City of Gosford Design Advisory Panel

Proposal: State Significant Development Application - Northside Private
Hospital, Gosford (SSD-10159)

Attachment A – Design Review Panel Advice

**Figure 13 |** Extract from Proposed Landscape Plans (base image: RTS)

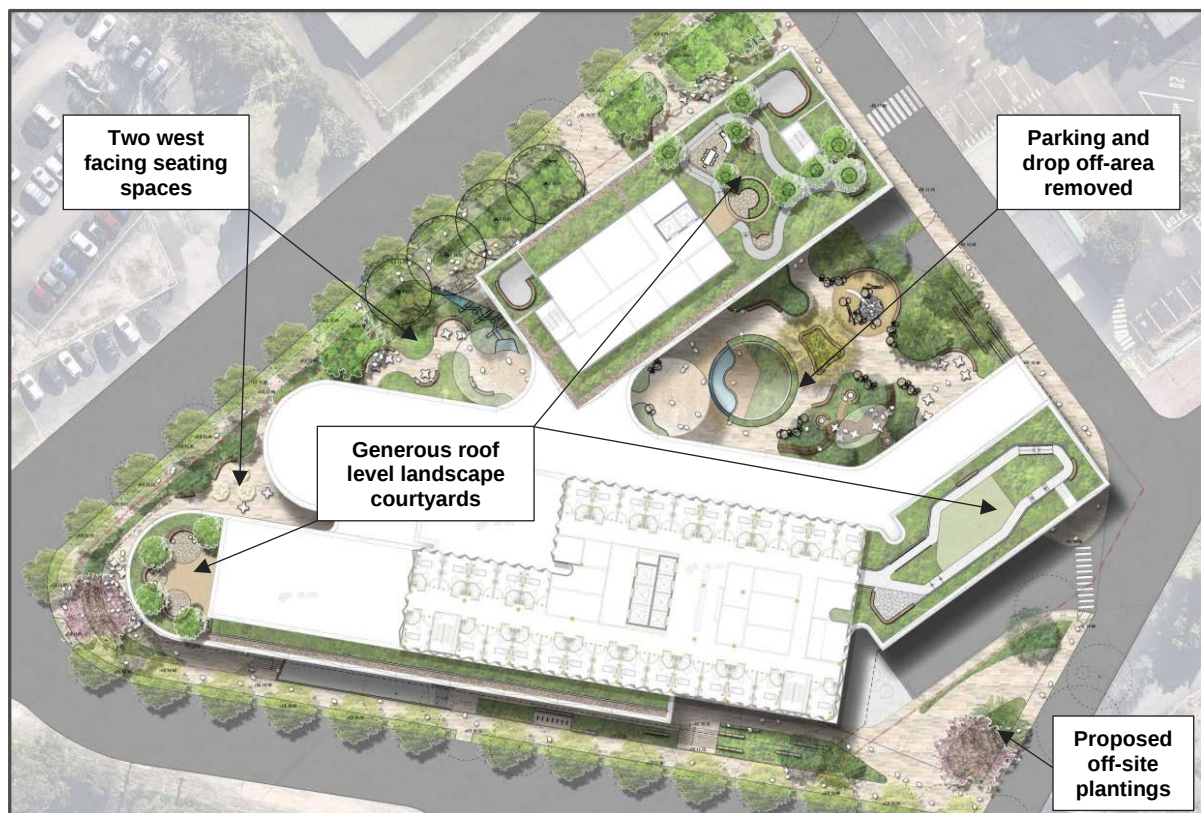
As per the detailed development plans the ground level connections from the public domain to the building and integration of landscape in both stages have improved significantly. The Faunce Street entry is significantly improved, the awning and step in the building provides a clear entry to the building. The entry to loading dock has been well resolved and is now supported. Landscape works are well integrated into the built form and provides enclosure to roof top space and some good spaces at the entrances to the building. The Panel has not reviewed the adequacy of the proposed plant species, but supports the scale of plantings.
